Peartree Hill Solar Farm

Environmental Statement Addendum Revision 4

Application Document Ref: EN010157/APP/8.2
September 2025

Figure 1.2: Land Areas and Cable Routes Plan with Field Numbering System

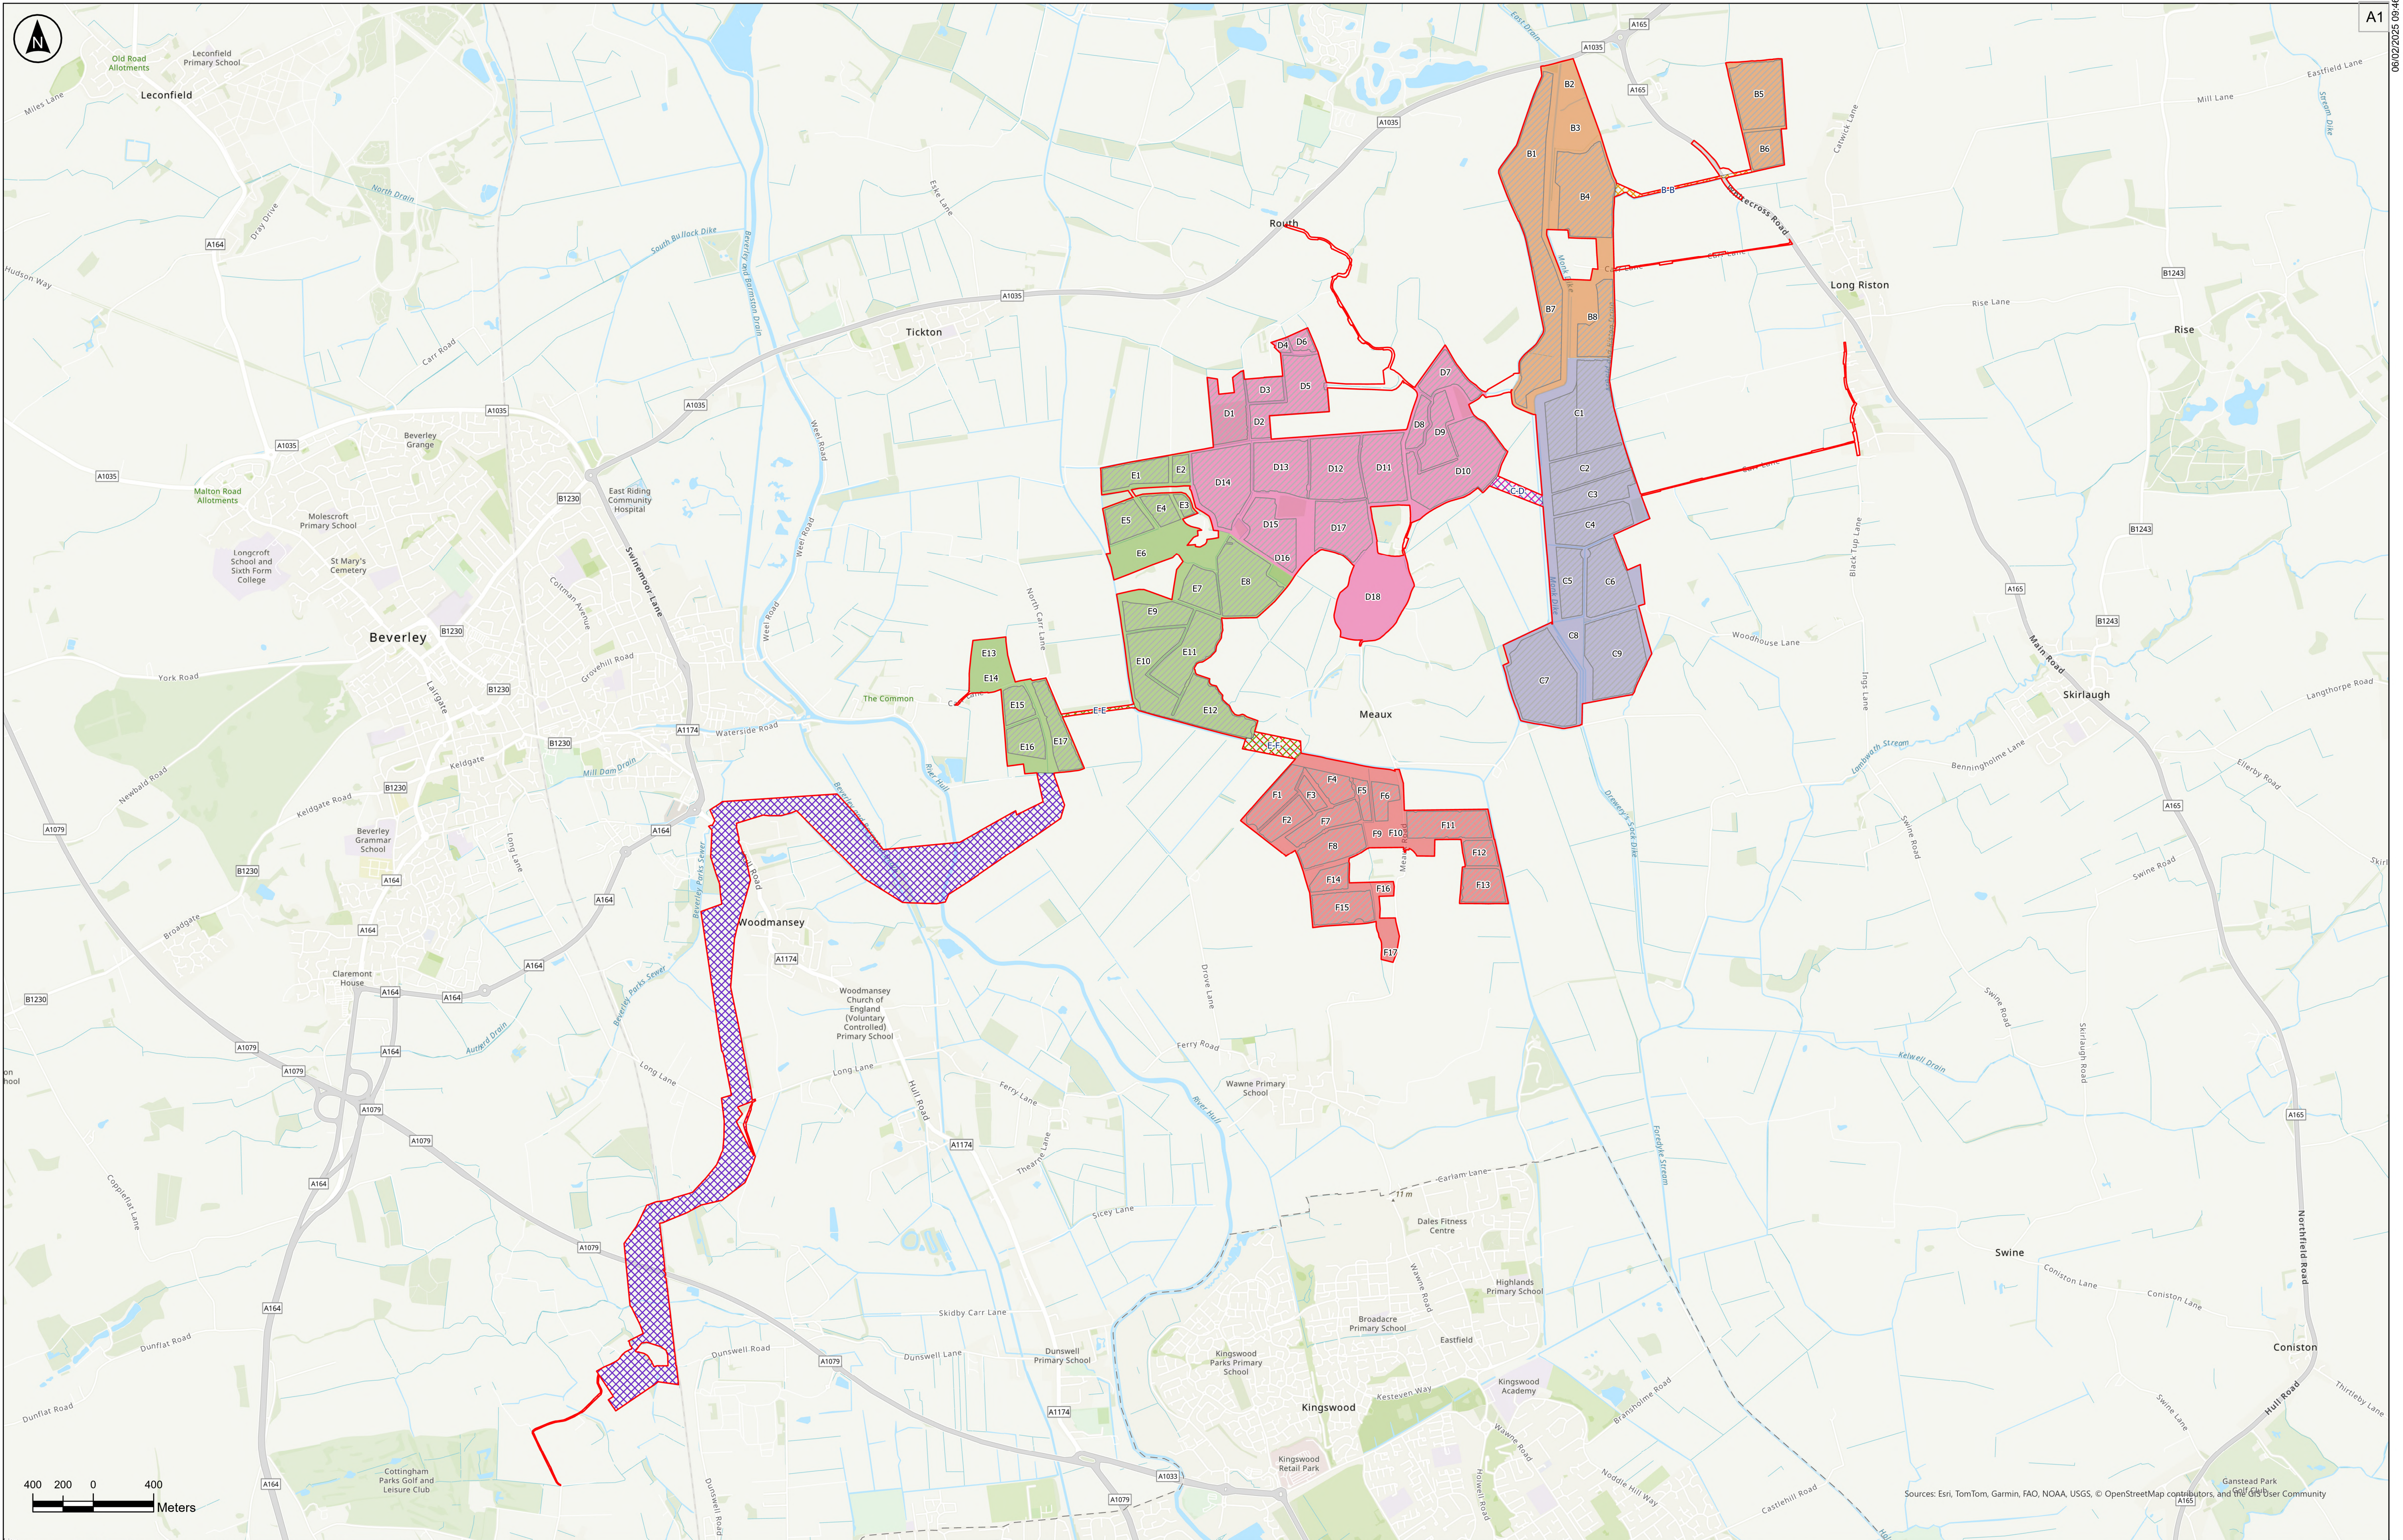
Document reference	Reason for amendment	ES Amendment July 2025
	Figure 1.2 also requires amendment to reflect the removal of plots 10-4, 10-5 and 10-6 as part of change/correction 2.	
ES Volume 3, Figure 2.1: Environmental Features Plan [APP-054]	Figure 2.1 requires amendment to reflect the removal of plots 10-4, 10-5 and 10-6 as part of change/correction 2.	
ES Volume 3, Figure 3.1: Indicative Operational Layout Plan [APP-055]	Figure 3.1 requires amendment to reflect the removal of a section of solar array from Land Area B as part of change/correction 1. Figure 3.1 also requires amendment to reflect the removal of plots 10-4, 10-5 and 10-6 as part of change/correction 2.	
ES Volume 3, Figure 3.2: Heights Parameters Zonal Plan [APP-056]	Figure 3.2 requires amendment to reflect the removal of a section of solar array from Land Area B as part of change/correction 1. Figure 3.2 also requires amendment to reflect the removal of plots 10-4, 10-5 and 10-6 as part of change/correction 2.

Figure 1.2: Land Areas and Cable Routes Plan with Field Numbering System

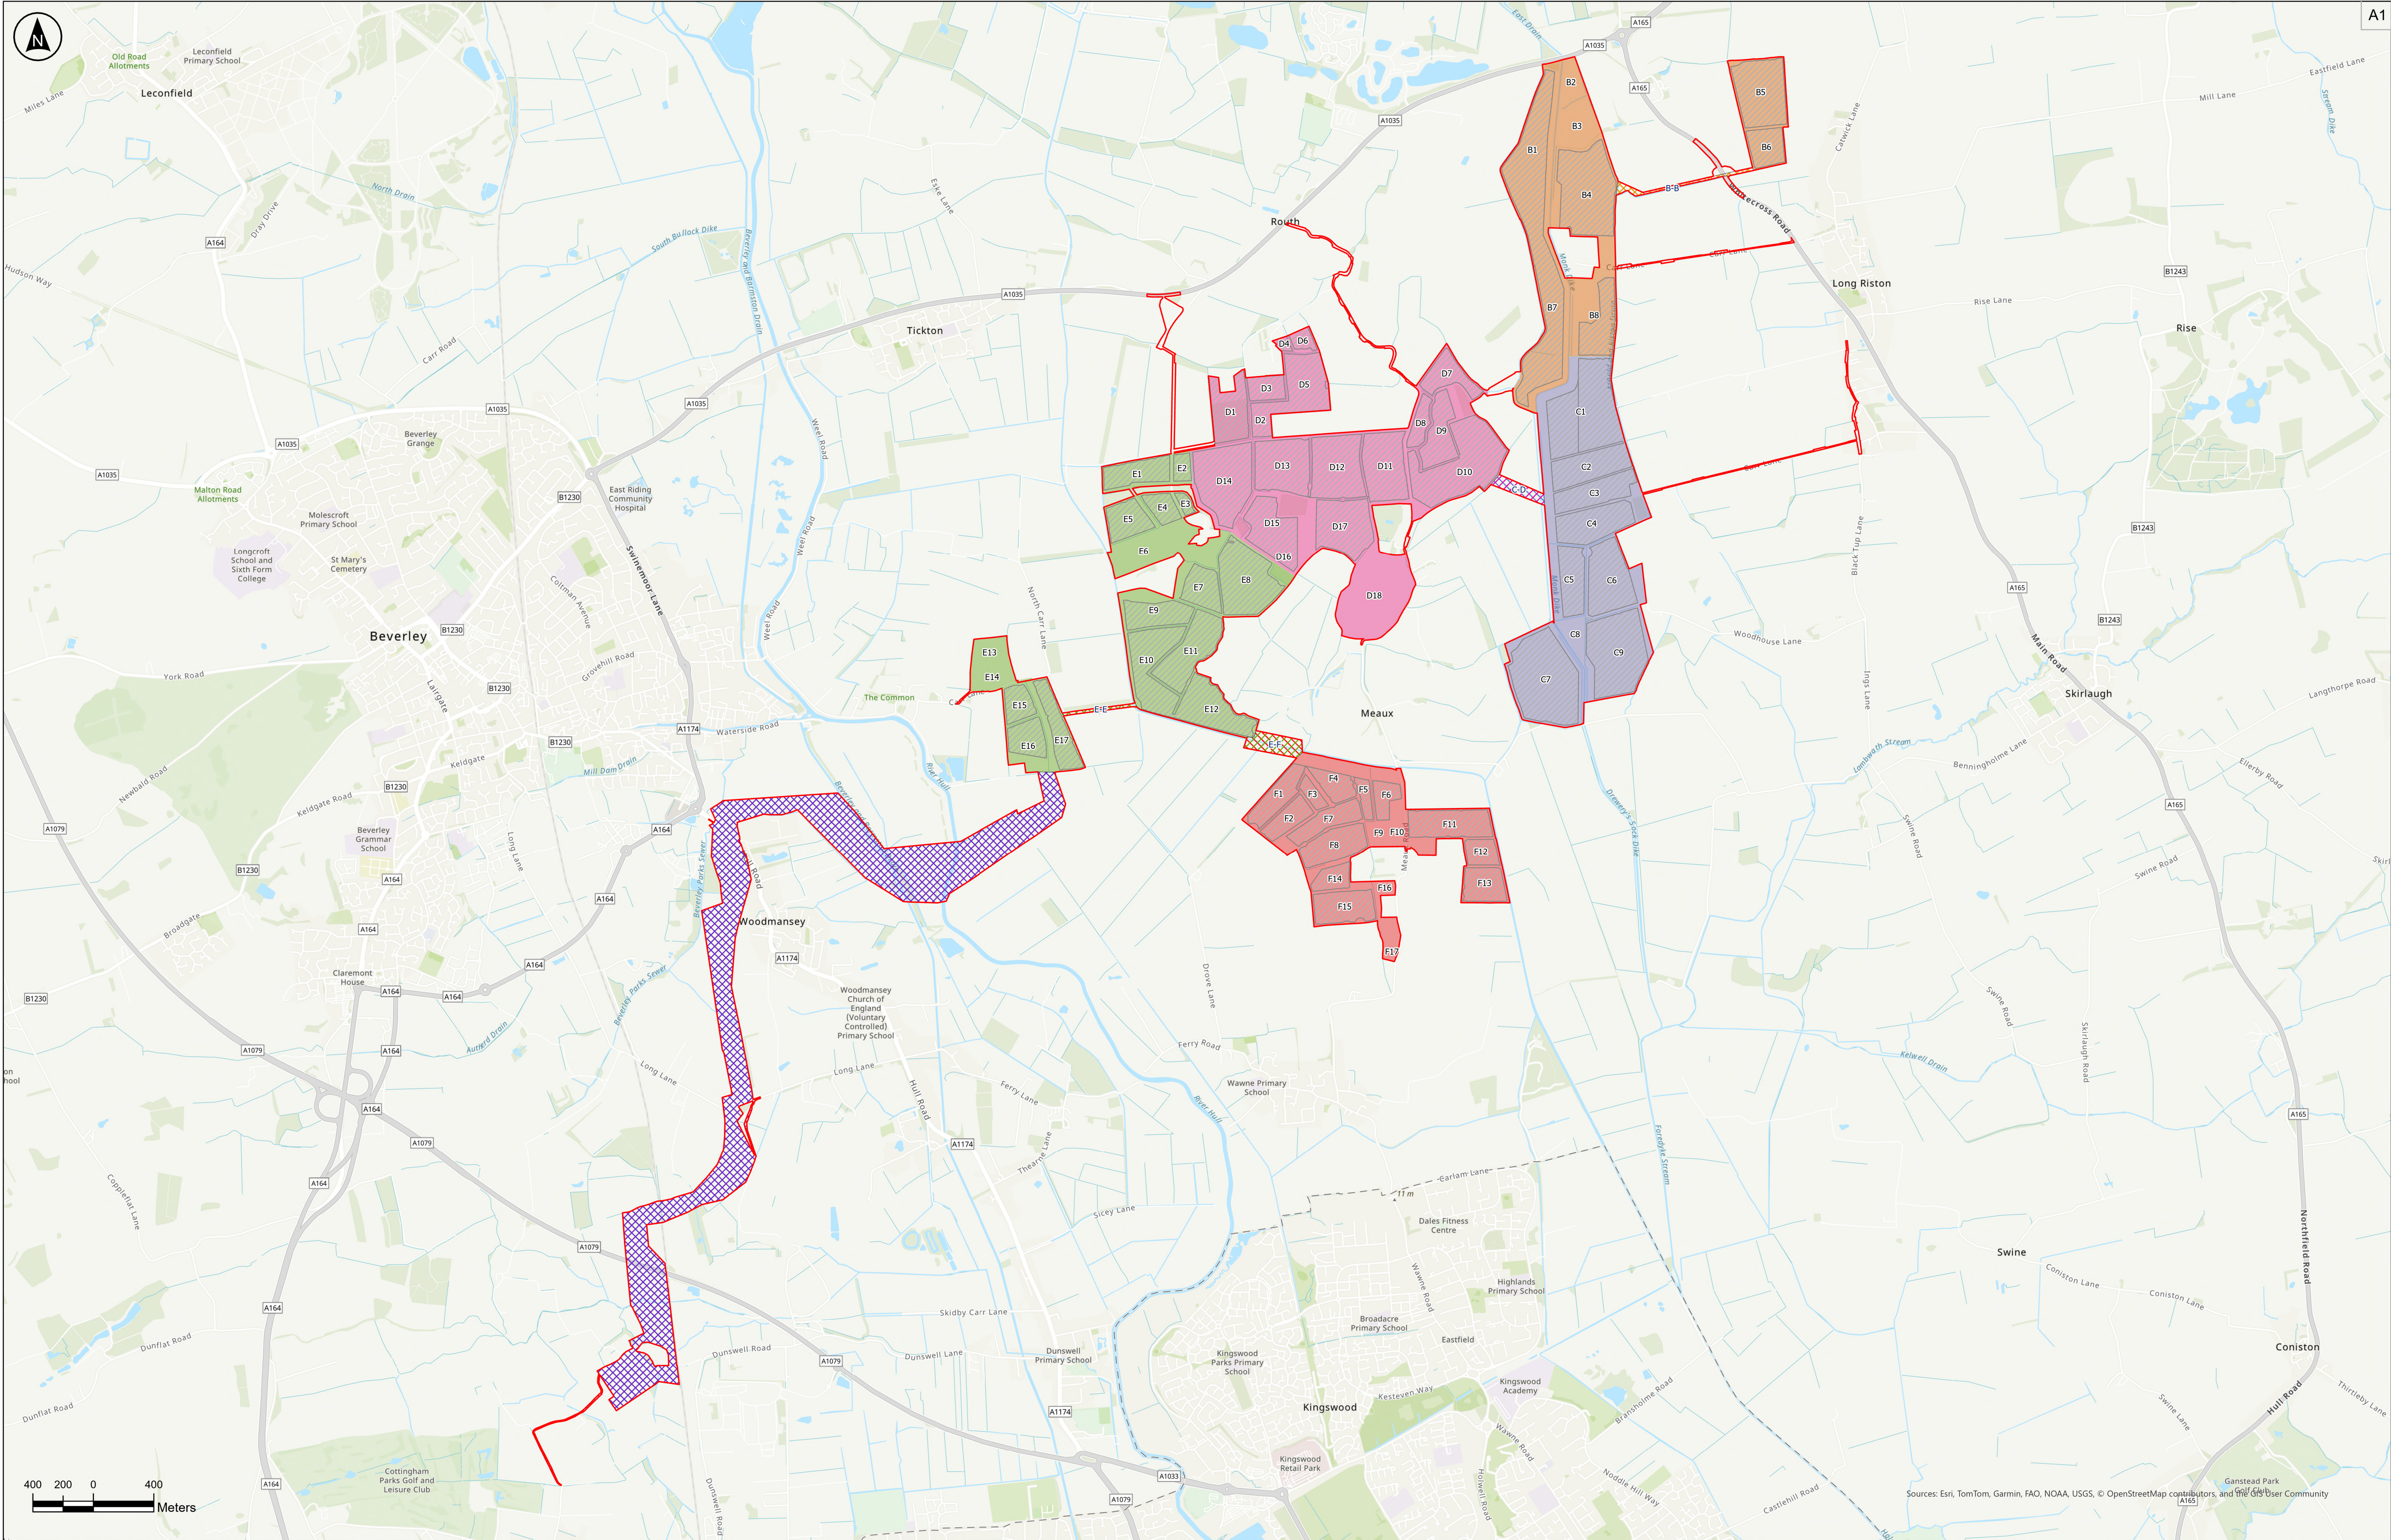
Document reference	Reason for amendment	ES Amendment September 2025
ES Volume 3, Figure 1.1: Order Limits and Administrative Boundaries [APP-052]	All changes to the DCO Application (excluding change 7) have meant that an update to the Order Limits is required.	Figure 1.1 is amended to show the proposed Order Limits following the change application in respect of changes 3, 4, 5, 6, 8 and 9. Resubmitted on 10 September 2025 as: ES Volume 3, Figure 1.1: Order Limits and Administrative Boundaries – Rev 2
ES Volume 3, Figure 1.2: Land Areas and Cable Routes Plan	All changes to the DCO Application (excluding change 7) have meant that an update to the Order Limits is required.	Figure 1.2 is amended to show the proposed Order Limits following

Document reference	Reason for amendment	ES Amendment September 2025
with Field Numbering System [APP-053]		the change application in respect of changes 3, 4, 5, 6, 8 and 9. Resubmitted on 10 September 2025 as: ES Volume 3, Figure 1.2: Land Areas and Cable Routes Plan with Field Numbering System – Rev 2
ES Volume 3, Figure 2.1: Environmental Features Plan [REP1-019 and REP1-020]	All changes to the DCO Application (excluding change 7) have meant that an update to the Order Limits is required. For change 9, sheet 2a has been added.	Figure 2.1 is amended to show the proposed Order Limits following the change application in respect of changes 3, 4, 5, 6, 8 and 9. Resubmitted on 10 September 2025 as: ES Volume 3, Figure 2.1: Environmental Features Plan – Rev 3
ES Volume 3, Figure 3.1: Indicative Operational Layout Plan [APP-055]	All changes to the DCO Application (excluding change 7) have meant that an update to the Order Limits is required. Change 7: Amendments required to show the updated layout.	Figure 3.1 is amended to show the proposed Order Limits following the change application in respect of changes 3, 4, 5, 6, 8 and 9. New layout shown for Change 7.
